Recommendation Report for Planning Permission

REF NO: BN/8/22/PL

LOCATION: Land to South and West (Rear) of Birchwood House
Church Lane
Barnham
PO22 0DB

PROPOSAL: Retention of existing site entrance (resubmission following BN/97/21/PL. This site is in CIL Zone 3 (Zero Rated) as other development.

title
Vision Splay Plan

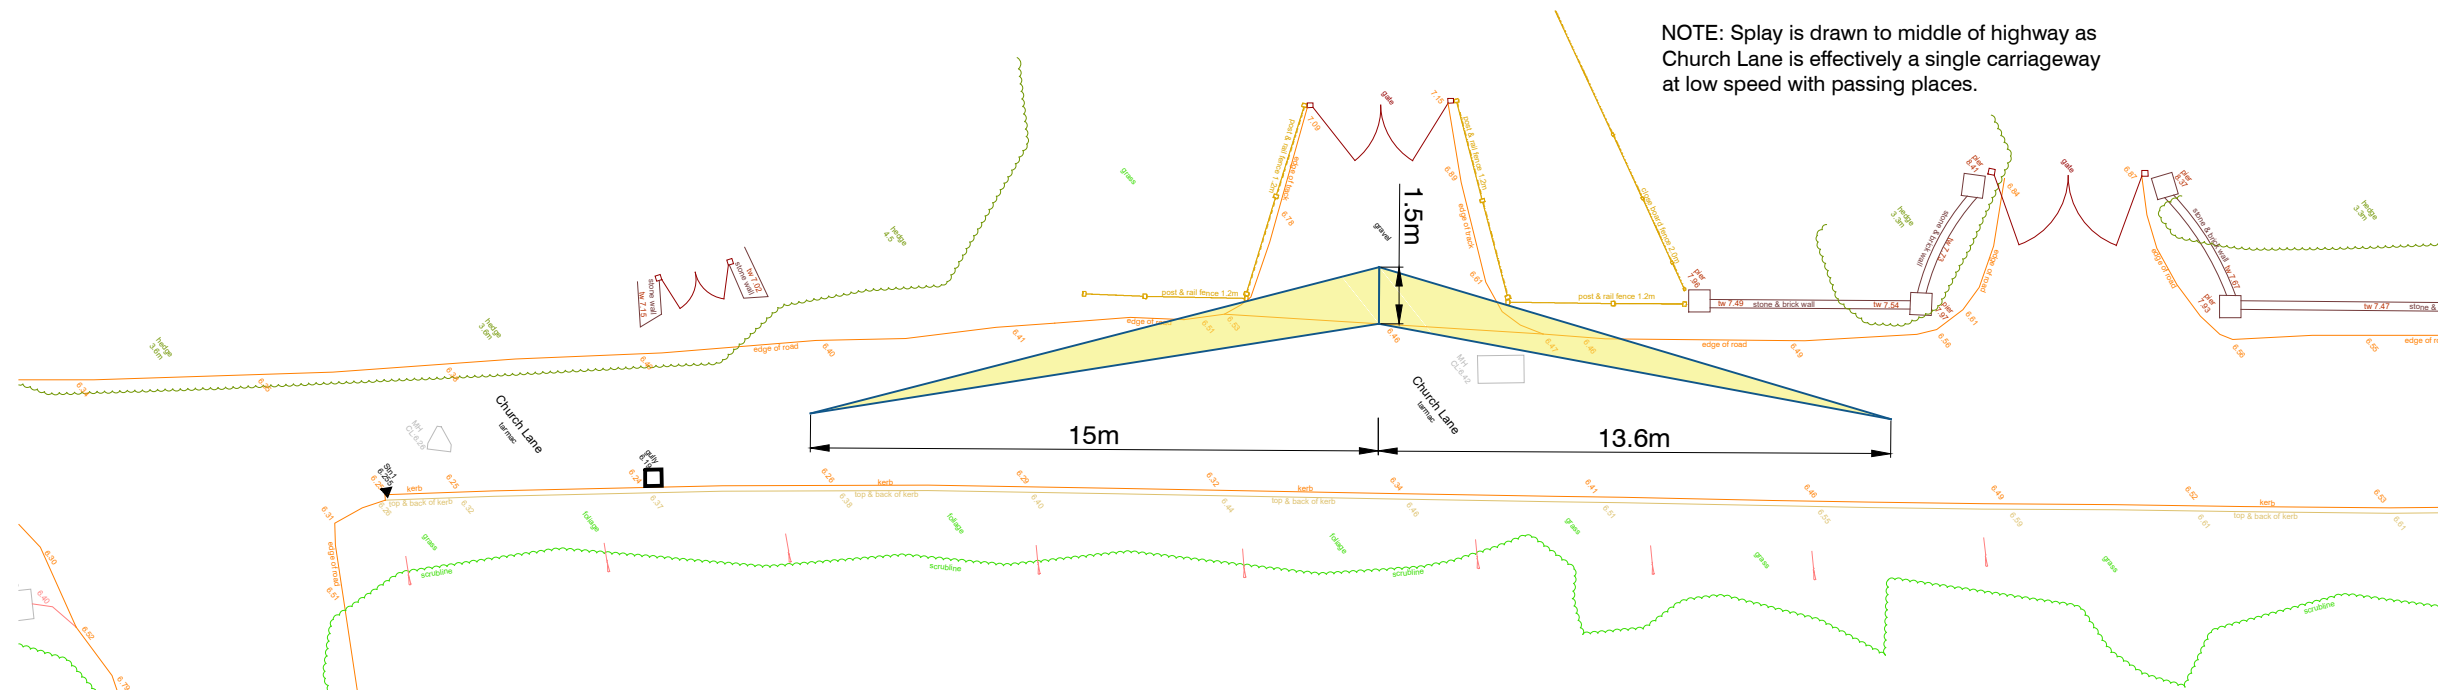
'Due to a lack of information, in particular the lack of Visibility Splay Plan and Speed Survey, the application currently fails to demonstrate that the new site access would have an acceptable impact on the operation and safety of the highways network.'

The access crossover, within the extent of the public highway is of a loose construction and does not meet WSCC crossover specification. The applicant would be invited to retrospectively apply for a crossover licence to regularise the works on the public highway. This will likely require the applicant to resurface the crossover, within the extent of the public highway to WSCC specification. The LHA would

The proposal is considered to comply with relevant Development Plan policies in that sufficient information has been provided to demonstrate acceptable highways safety impacts and the proposed development would not have an unacceptable impact on the surrounding environment.

consider the application difficult to resist citing highway safety reasons subject to informative note."

client			
Mrs Brazil			
project			
Access to Land Adjacent to Birchwood House, Church Lane, Barnham. PO22 0DB.			
title			
Site Layout Plan, Block Plan and Elevation			
date	scale @ A3	drawn	chkd
Jan 2022	1:500, 1:100	GC	GC
project no.	drawing no.	rev	
2142	P02	02

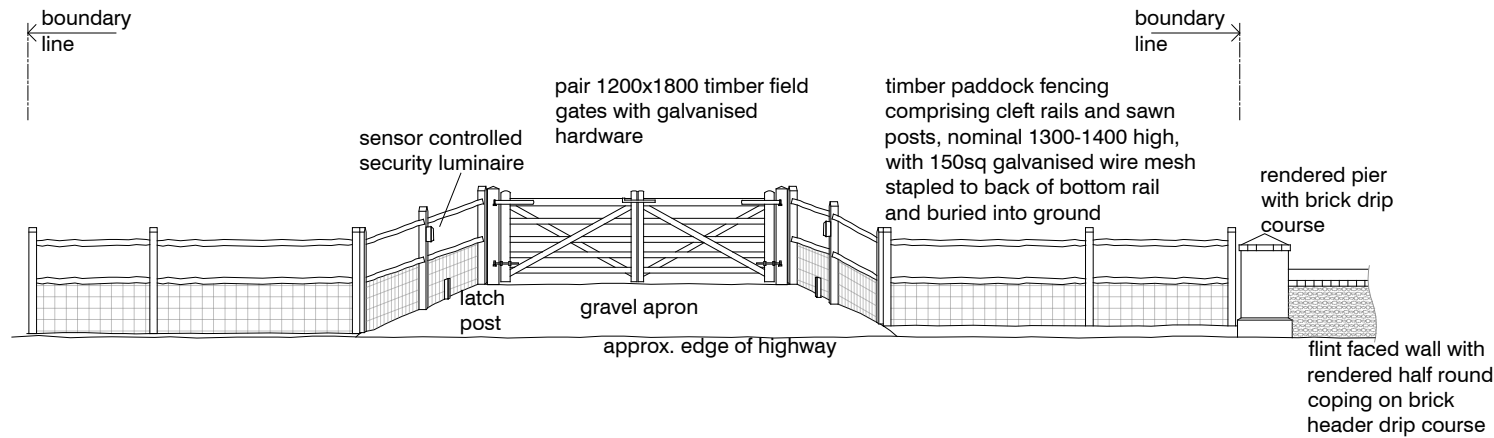
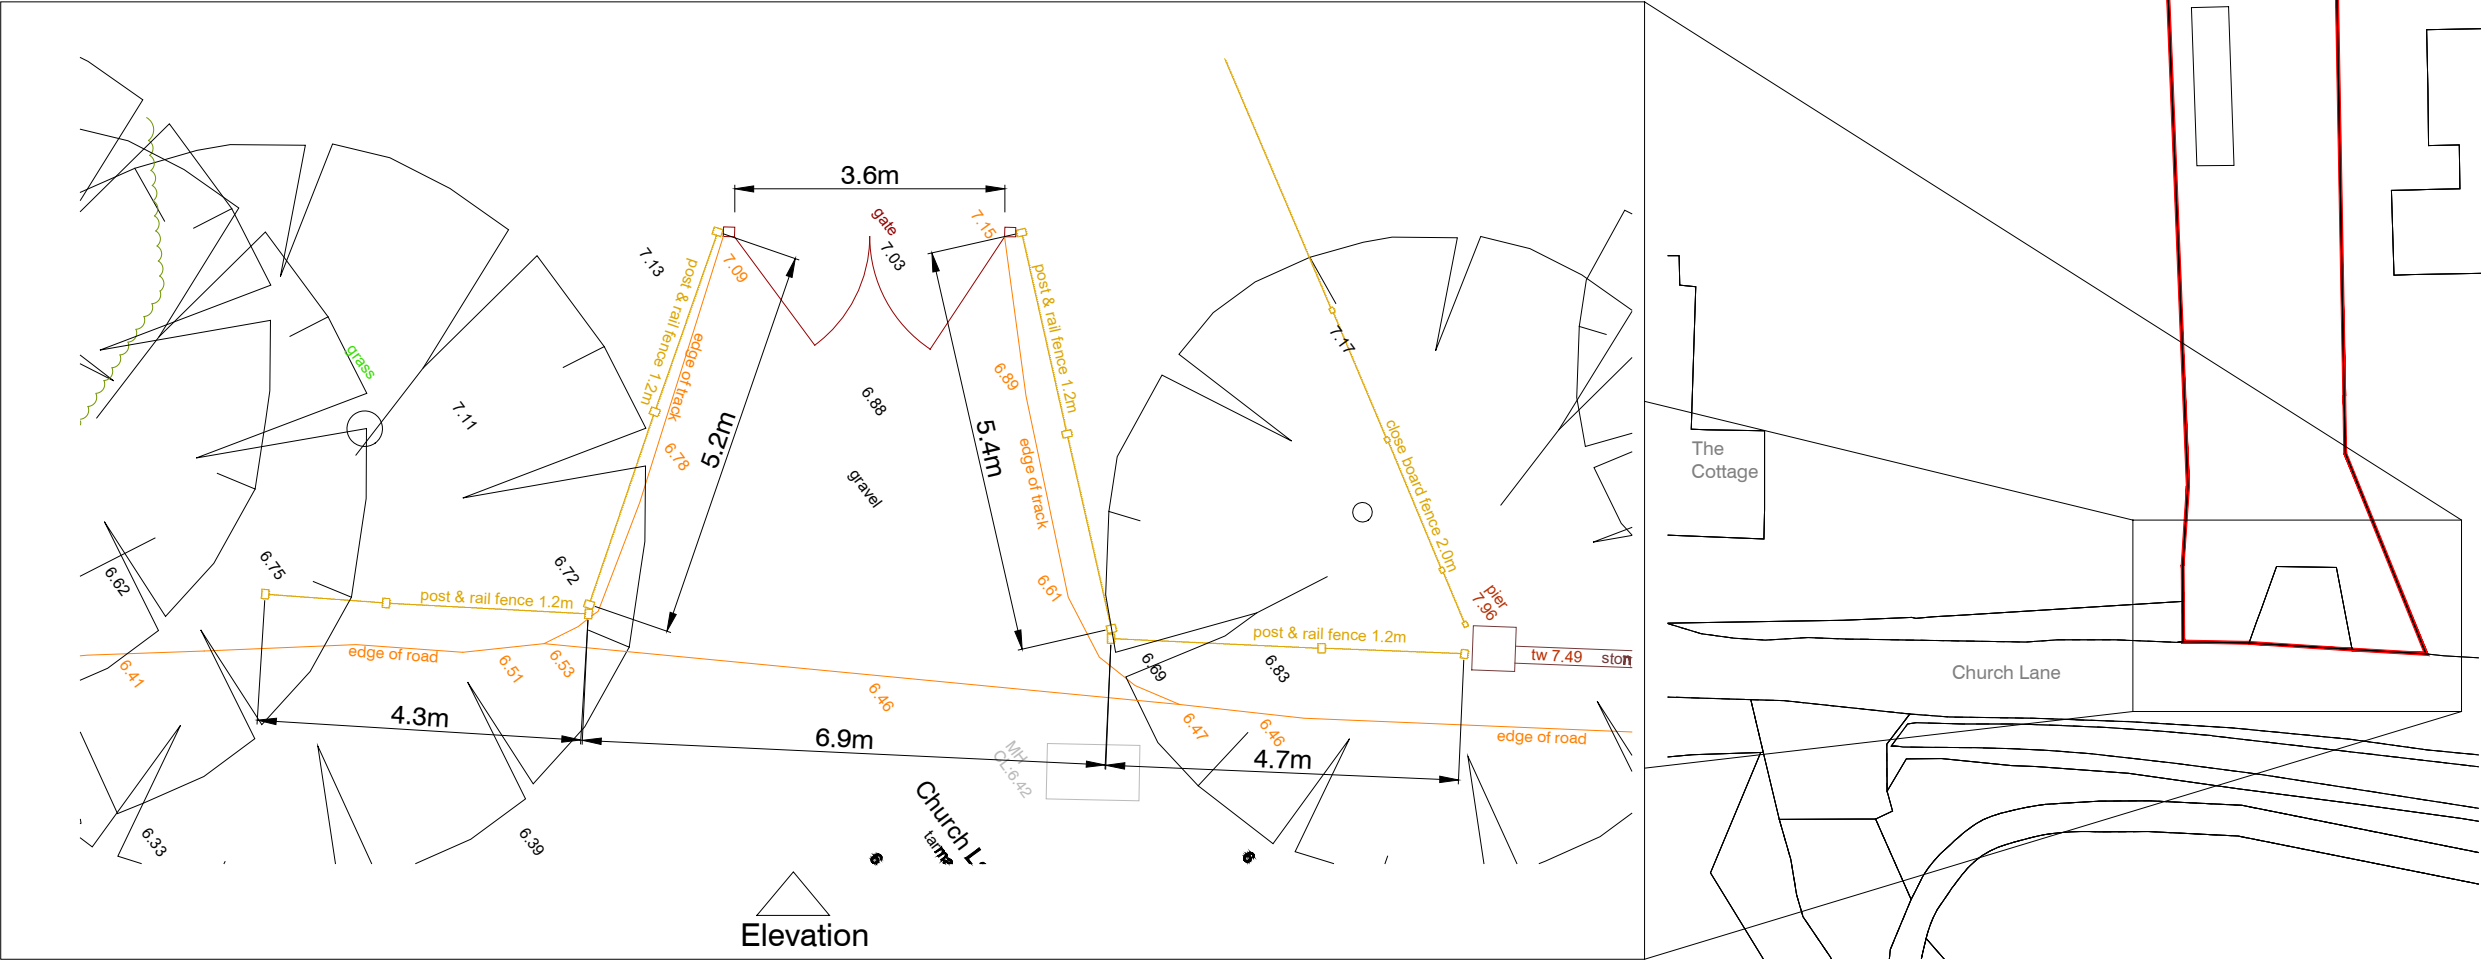
In respect of the brick and flint boundary wall, it is acknowledged that a considerable portion of walling has been removed to facilitate the creation of the access. This has affected the appearance of the area in which the flint walls are typical feature of Church Lane, however, this part of Church Lane is not in the Barnham Church Lane Conservation Area and there are not any policies in the Arun Local Plan or Barnham & Eastergate Neighbourhood Development Plan which would protect them.

Recent historic imagery of the site indicates the area was overgrown and consisted of trees, scrub and a section of brick/flint walling. A considerable portion of brick/flint walling has been removed to facilitate the creation of the new access. This loss is regrettable, since brick and flint walling forms a positive characteristic of the area. Significant vegetation, including the trees, has been removed. The removal of the wall did not require planning permission.

The entrance comprises a pair of 1.2m x1.8m timber field gates and timber fencing comprising cleft rails and sawn posts, 1.3m to 1.4m high, with galvanised wire mesh stapled to the back of the bottom rail and buried into ground.

Natural, porous gravel, rather than impermeable paving, has been used which is appropriate in this rural context and accords with the Parish Design Guide. The height of the boundary treatment would be similar to the height of the pilasters adjacent at Birchwood House and would be appropriate in this context.

These works have affected the area which is lined with flint walls in a combination with timber gates. The entrance does not cause the unacceptable harm and when buffered with vegetation it would merge with existing vegetation. The loss of this section of walling in terms of harm to character does not justify a refusal.

The entrance does not have an unacceptable impact on the street scene. The proposal is in a general accordance with policies D SP1 and D DM1 of the ALP and the principles in the B&E Design Guide (2020) and ADC Design SPD (2021).
